Recommendation Report for Planning Permission for Works or Extension to a Dwelling

REF NO: FG/121/20/HH

LOCATION: 10 South Drive
Ferring
BN12 5QU

PROPOSAL: Proposed front and rear extensions, to include raising the ridge height of the existing bungalow to create a new first floor level and proposed swimming pool.

Job Number: AR-146 Drawing Number: 03 Revision: Revision

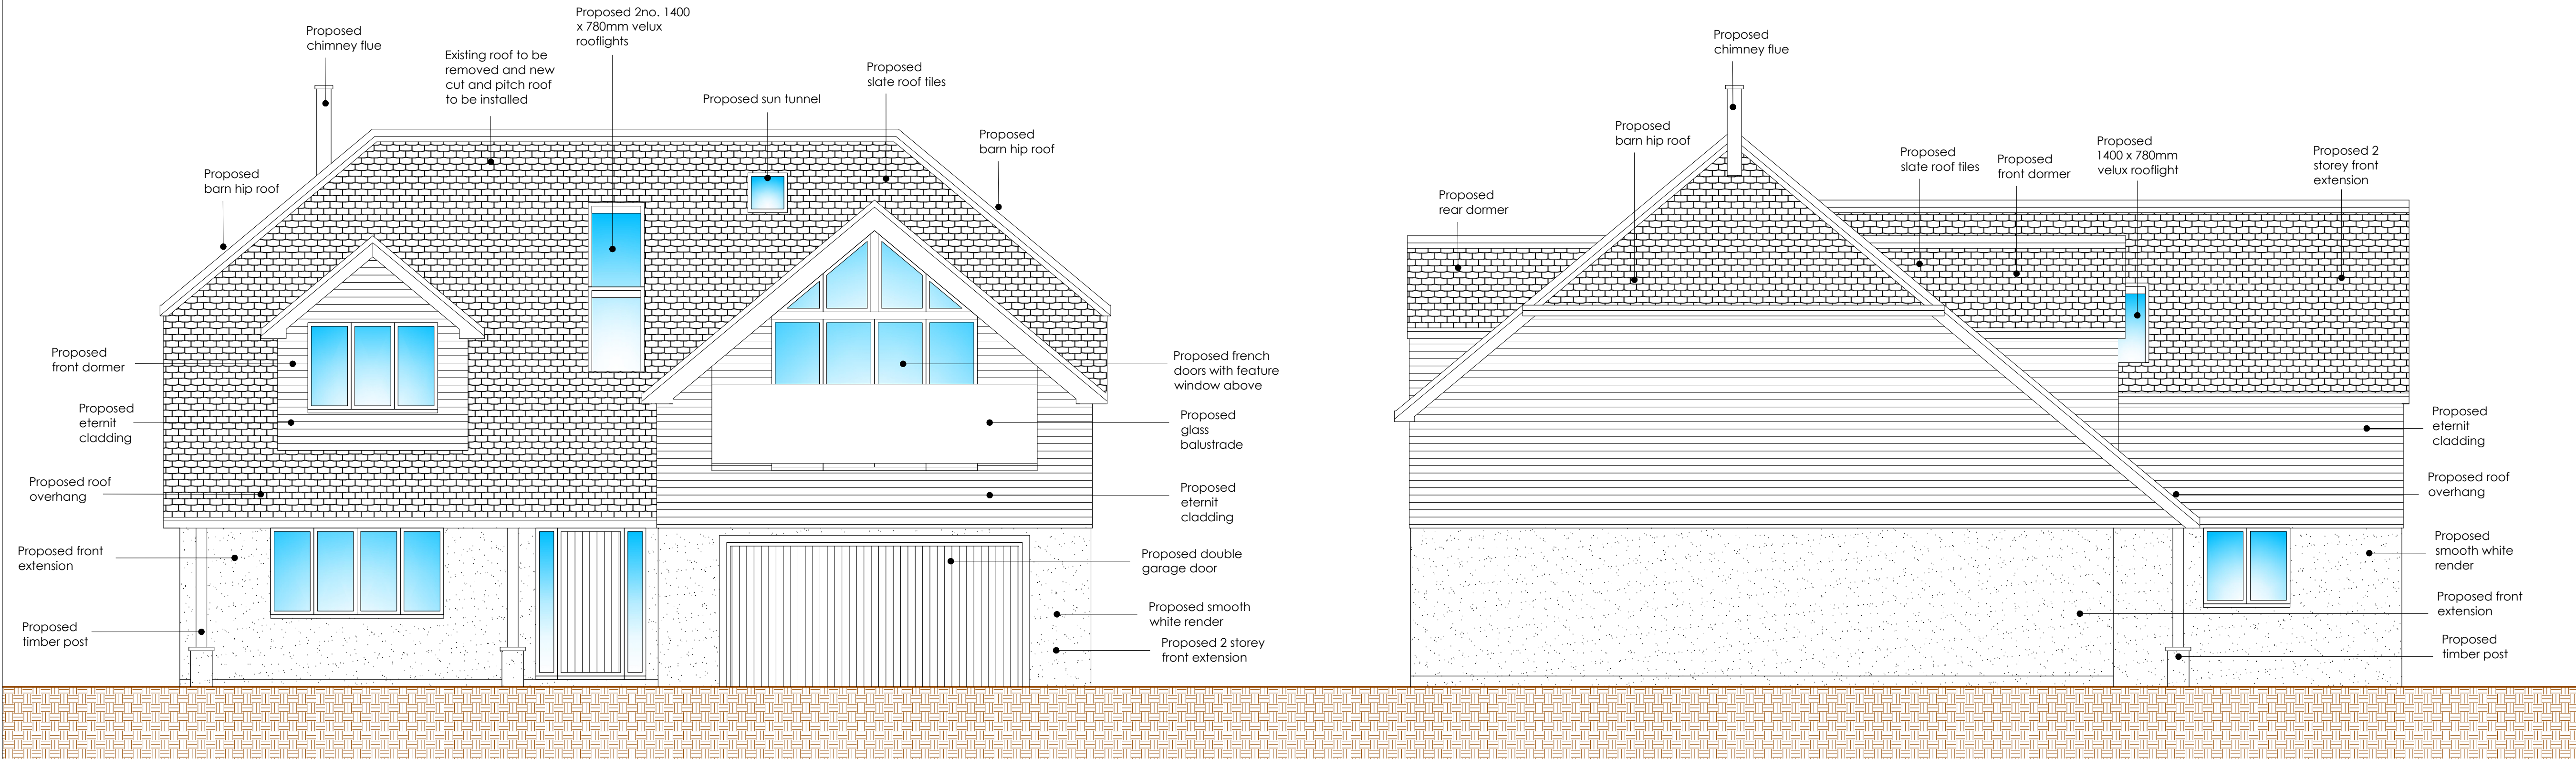
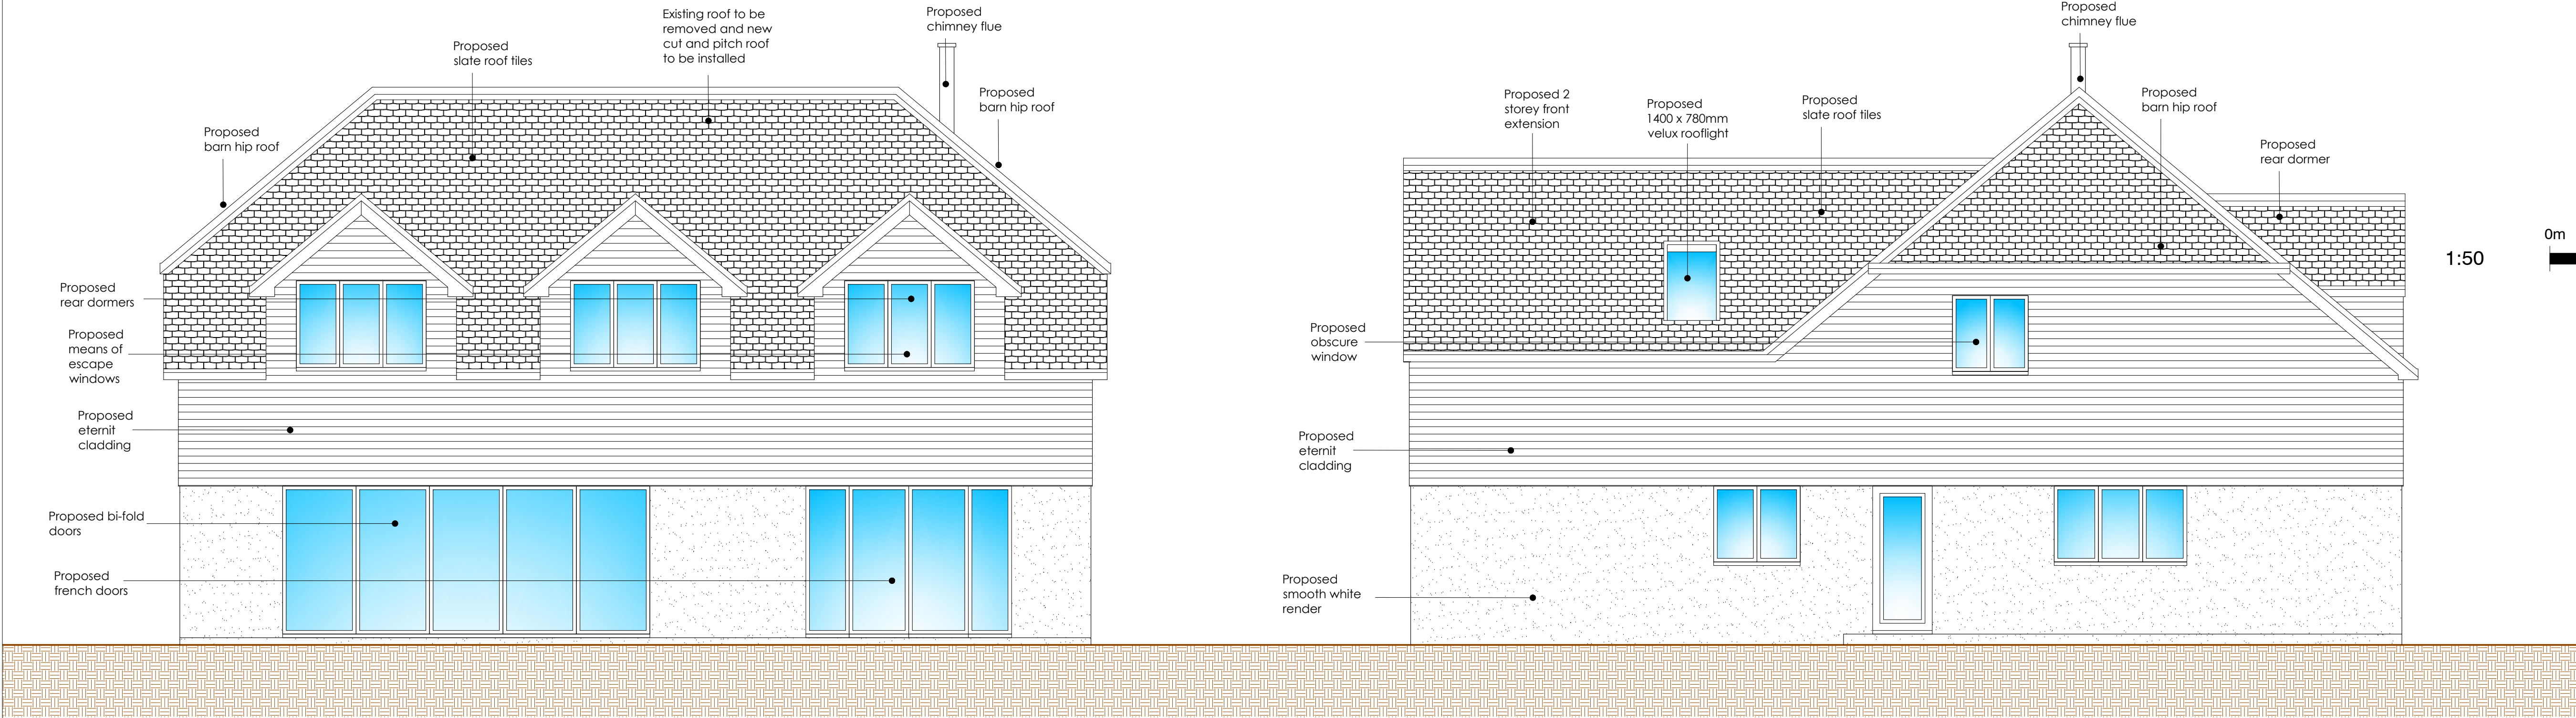
The roof would be raised from 5.04 metres to 7.74 metres in height to incorporate an entirely new first floor. The footprint of the building would be extended 1.95 metres at the rear and 4.00 metres on the east side at the front. The dwelling is proposed to be extended such that it will turn from being a single storey dwelling to a two storey property.

The side windows at first floor facing neighbouring properties would be conditioned to be obscure glazed and fixed shut and therefore no undesirable overlooking would occur.

The dormer windows would be sufficiently distant (in excess of 25 metres in each case) from properties opposite and to the rear so as to avoid an unacceptable loss of privacy.

- 3 The windows at the first floor on the east elevation of the building shall at all times be glazed with obscured glass and be fixed to be permanently non-opening below 1.8 metres in height from finished floor level.
